Application No: R/31/21/HH
Site Address: West Hayne 19 Angmering Lane East Preston BN16 2TA
Description of works: Single storey side extension, single storey rear extension and raising of garage roof to form 1st floor for storage

Thank you for your internet representation made on 29th April 2021 which has been recorded as no objection with the comments as follows:

SITE PLAN – SCALE 1:200

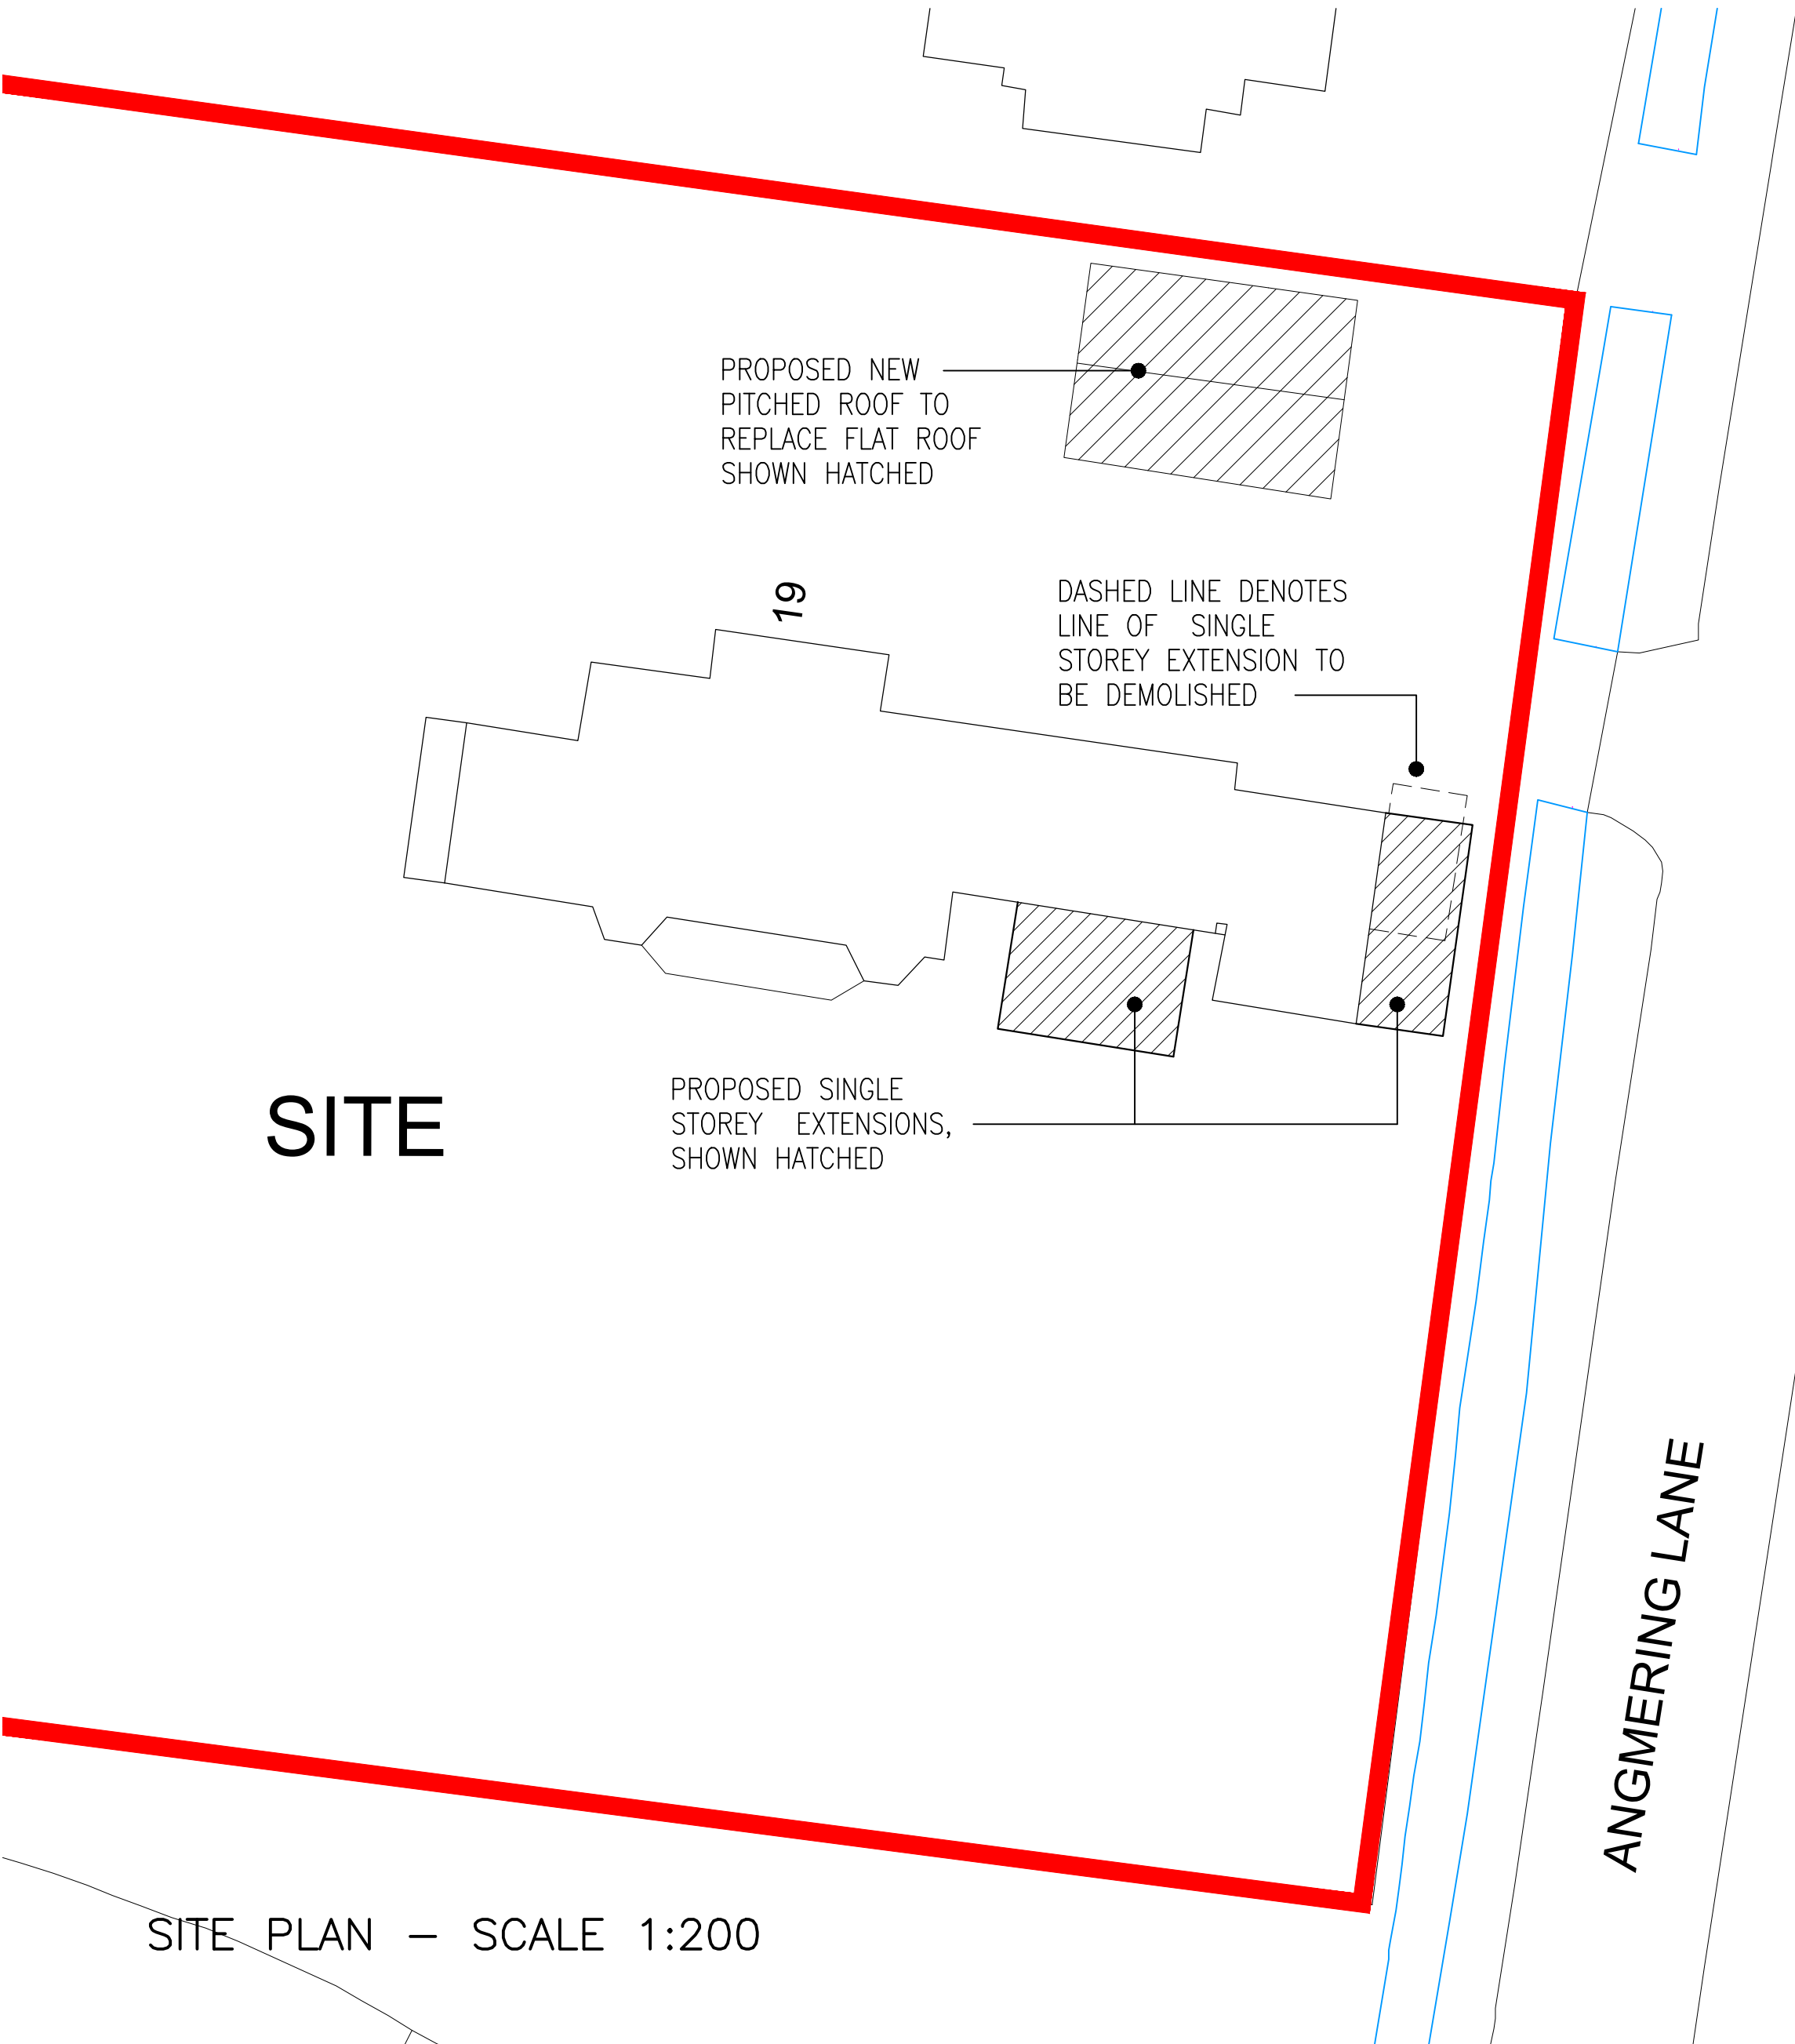
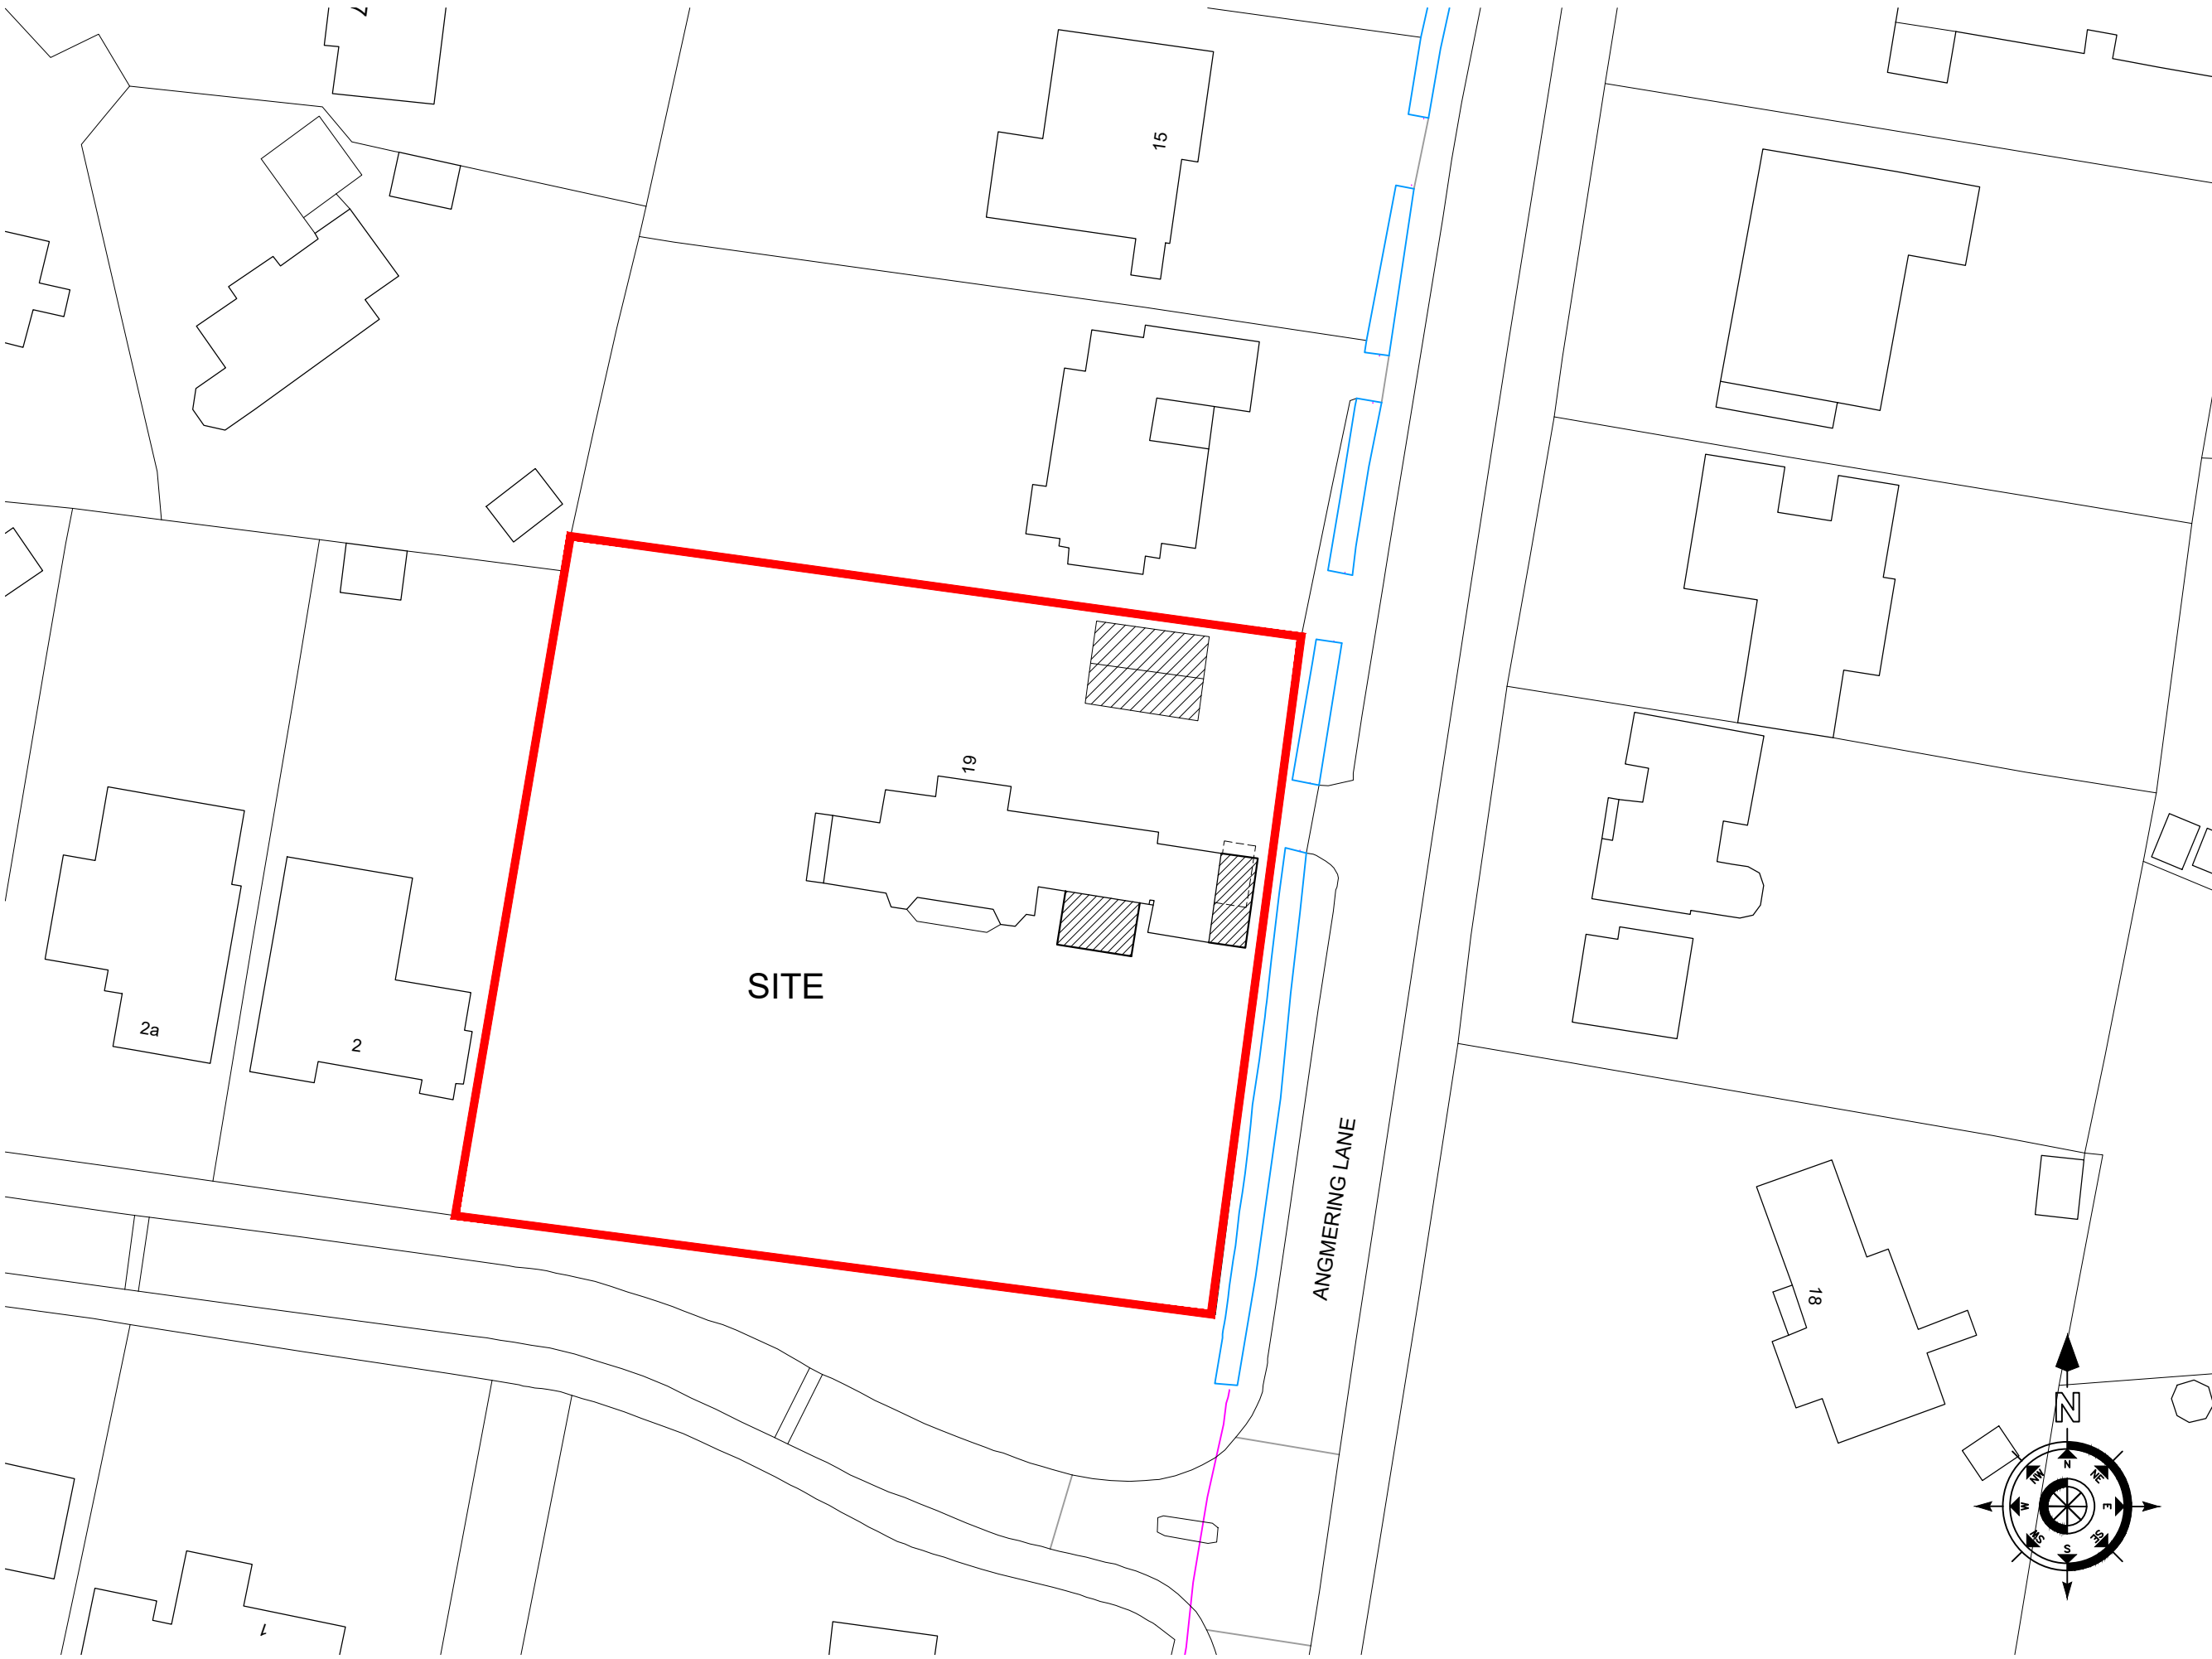
My Council has noted the above application and wishes to raise no objection to it, but expressed its concern that the Site Plan submitted for consideration was inaccurate and misleading, as an additional property had been constructed to the South of 19 Angmering Lane, within the original Site boundary, under Planning Application No. R/141/18/PL, and this was not shown. It also agreed that the local Planning Authority should advise the Applicant accordingly, and any necessary action should be taken to rectify this inaccuracy.
